COLORADO GEOLOGICAL SURVEY

June 5, 2017

Subject: Meadowbrook Crossing Residential – Preliminary Plan (revised)
File Number SP-17-002; El Paso County, CO; CGS Unique No. EP-17-0035_2

**MEADOWBROOK CROSSING
PRELIMINARY PLAN**
Colorado Springs, CO

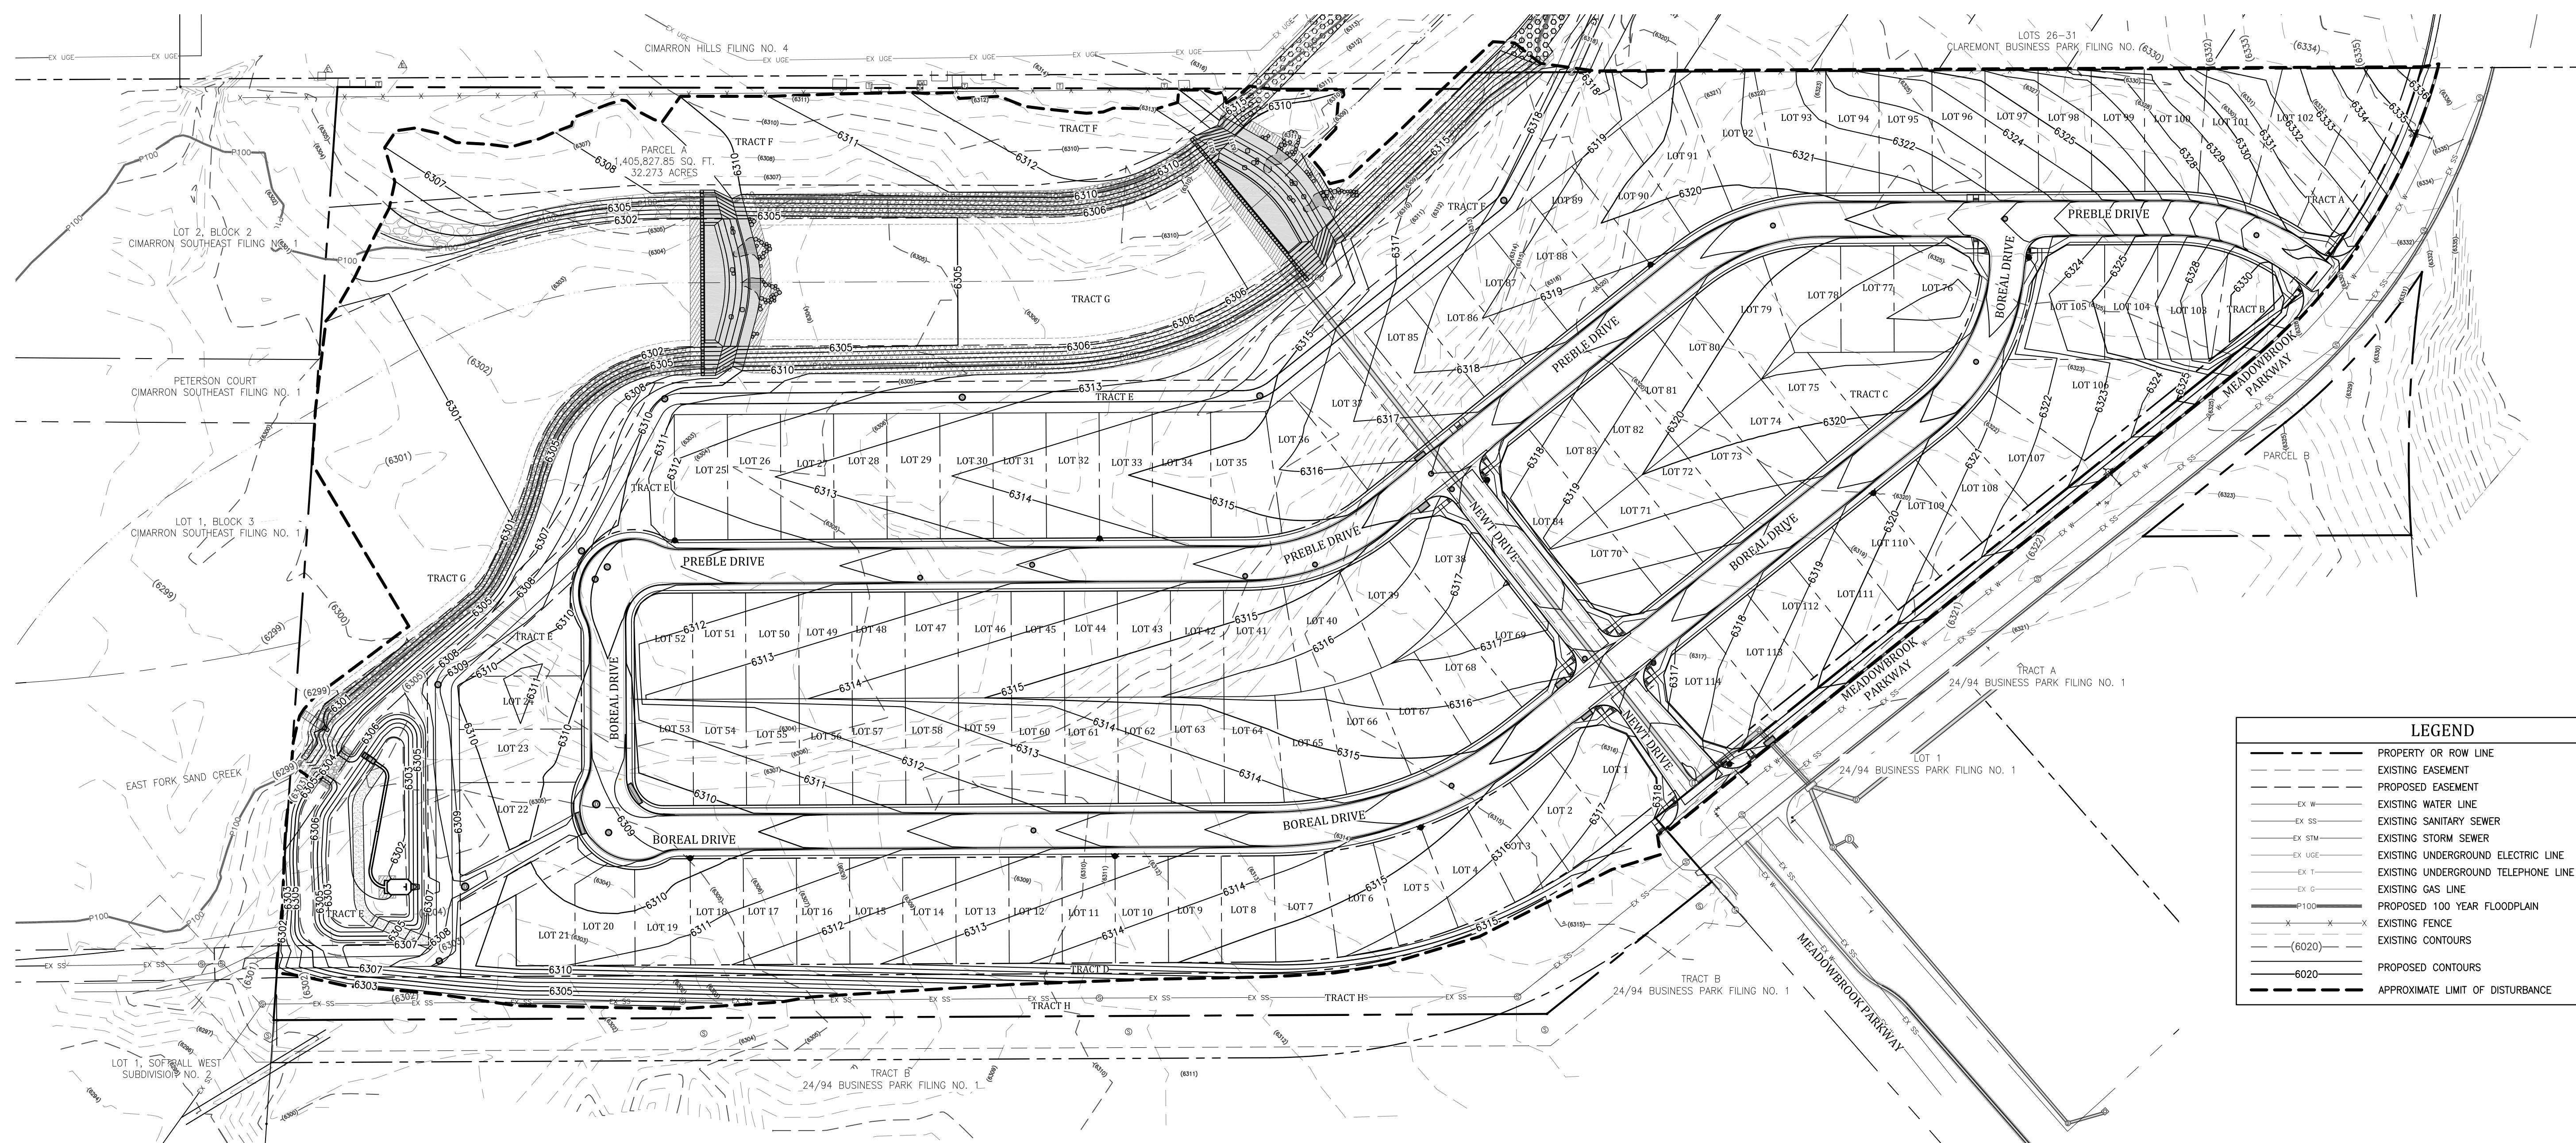
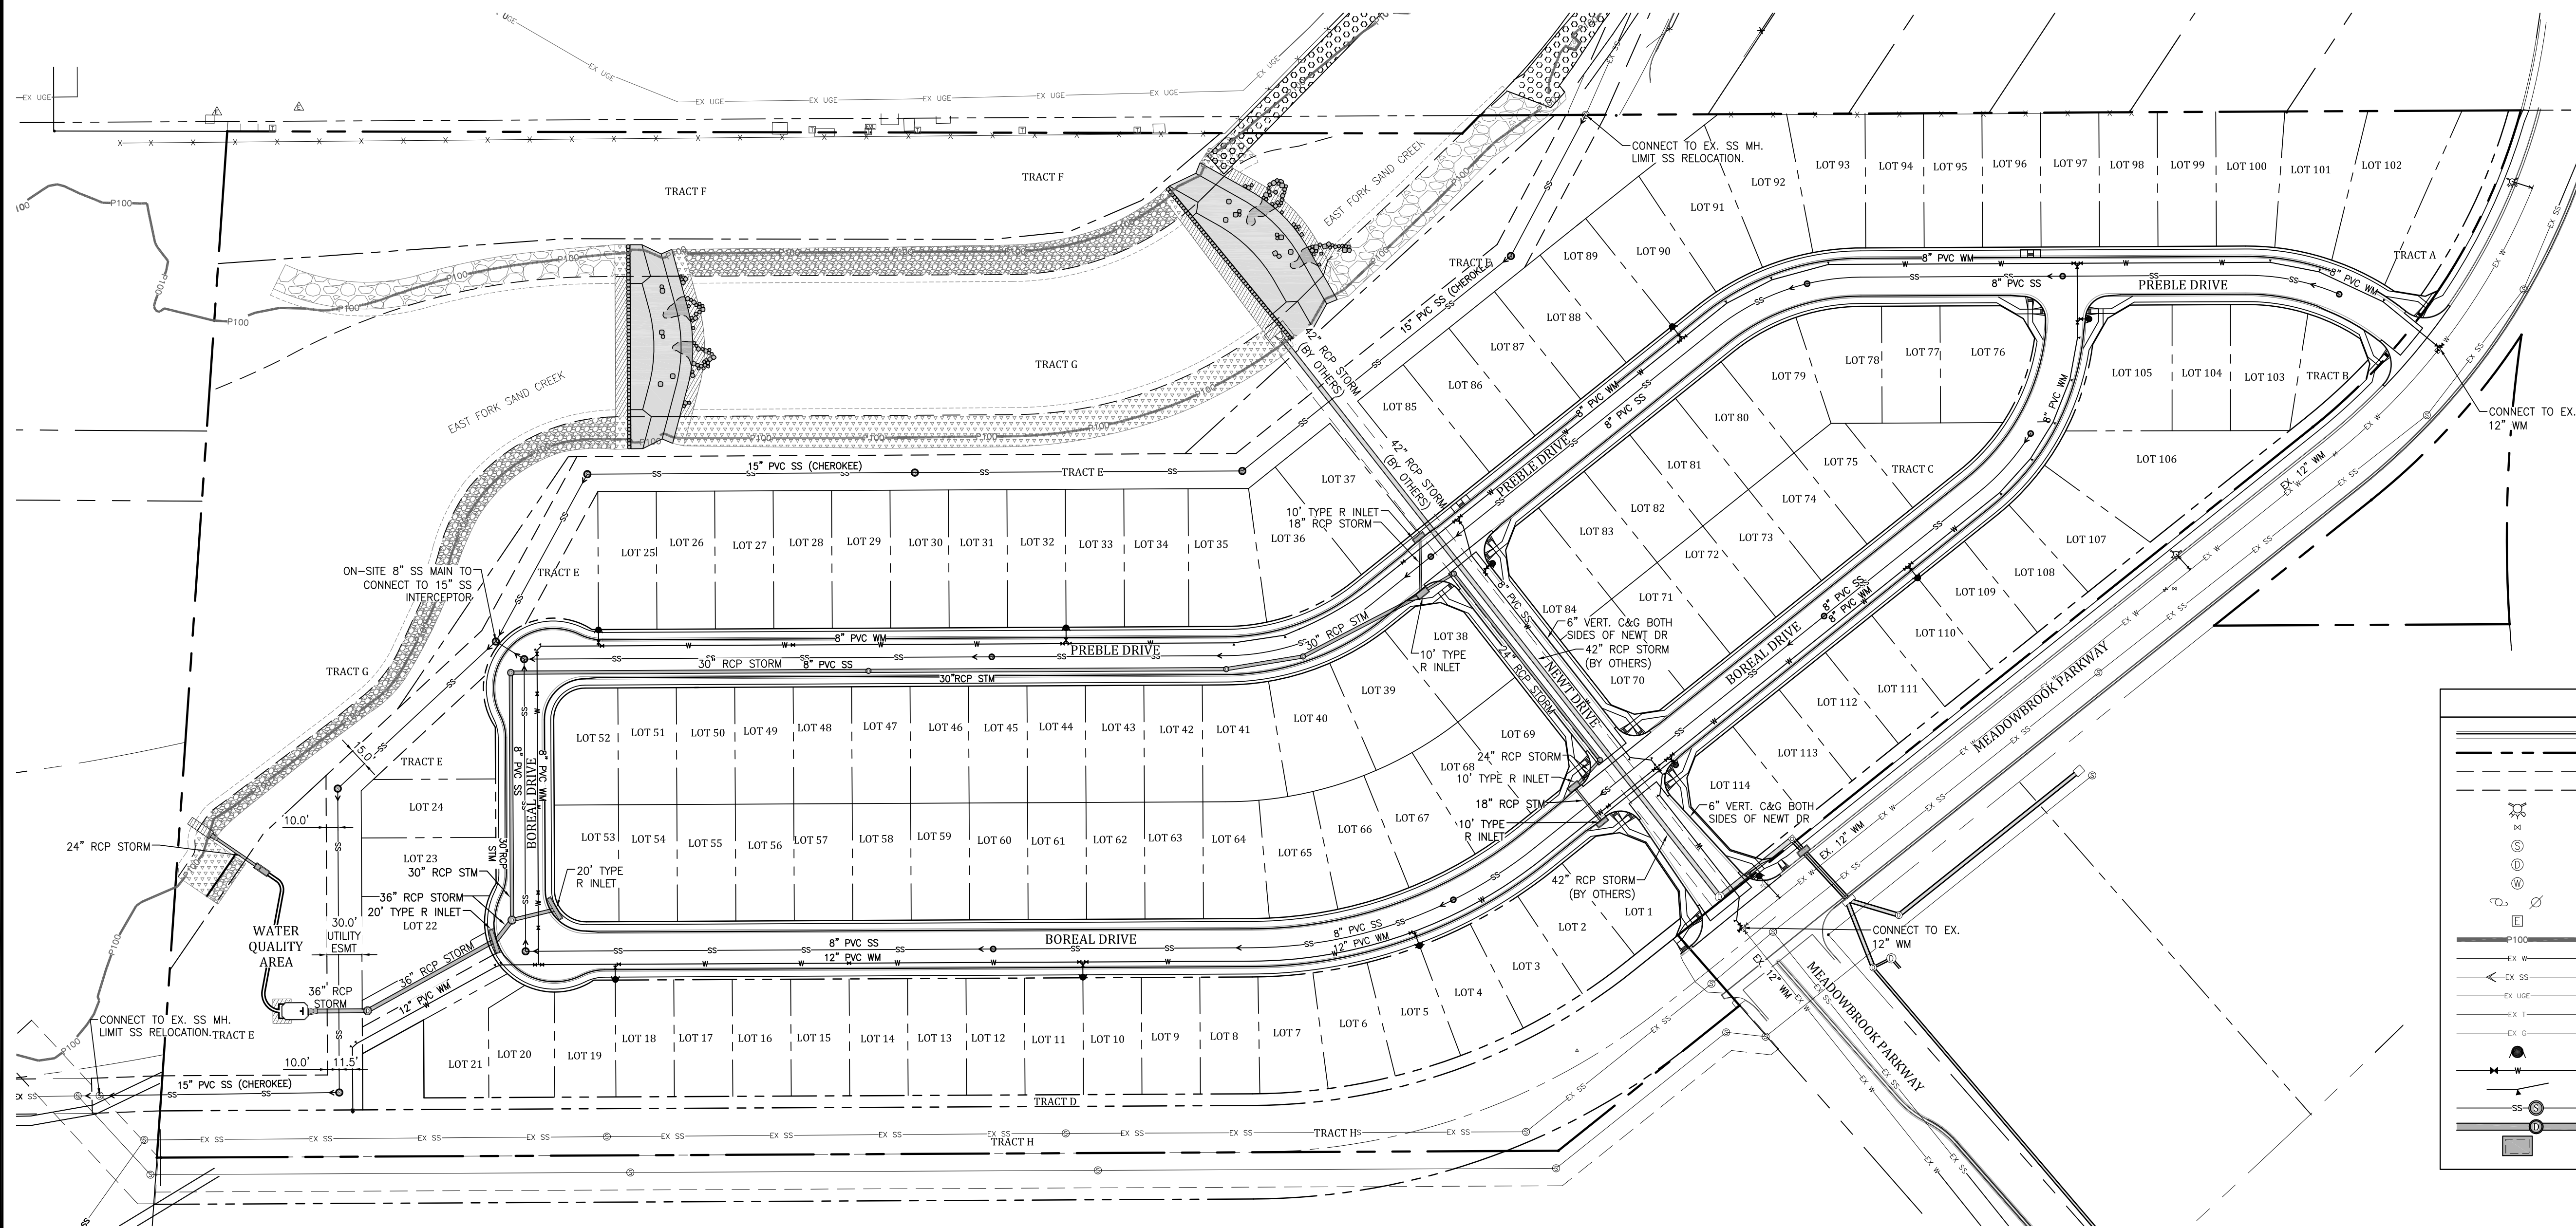
Shallow groundwater. The very shallow groundwater area identified by CTL is correctly shown on the preliminary plan. **The current referral documents do not include the final plat, so we cannot determine whether the final plat has been corrected, as recommended in our 2/16/2017 review letter, to identify the shallow groundwater area.** Basements should not be considered feasible on, at a minimum, proposed lots 25 through 31 and 46 through 52 unless site grades are raised sufficiently to provide a minimum 3 ft. separation distance between lowermost floor levels and shallowest anticipated seasonal groundwater levels.

Erosion and erosion-related slope instability along Sand Creek East Fork. According to FEMA Flood Insurance Rate Map panels 08041C0752F and 08041C0754F (March 17, 1997), portions of the site are located within the Sand Creek East Fork 100-year flood zone. The applicant states that drainage improvements are planned to remove proposed lots from the flood zone, and that a Letter of Map Revision (LOMR) has been submitted to FEMA. CGS recommends that all proposed lots be set back an adequate distance from channel slopes to reduce hazards associated with erosion, shallow downslope creep, undercutting, and erosion-related slope instability. **CTL should verify that the 30 ft. setback/sanitary sewer easement shown on the preliminary plan behind proposed lots 24 through 33 is adequate.**
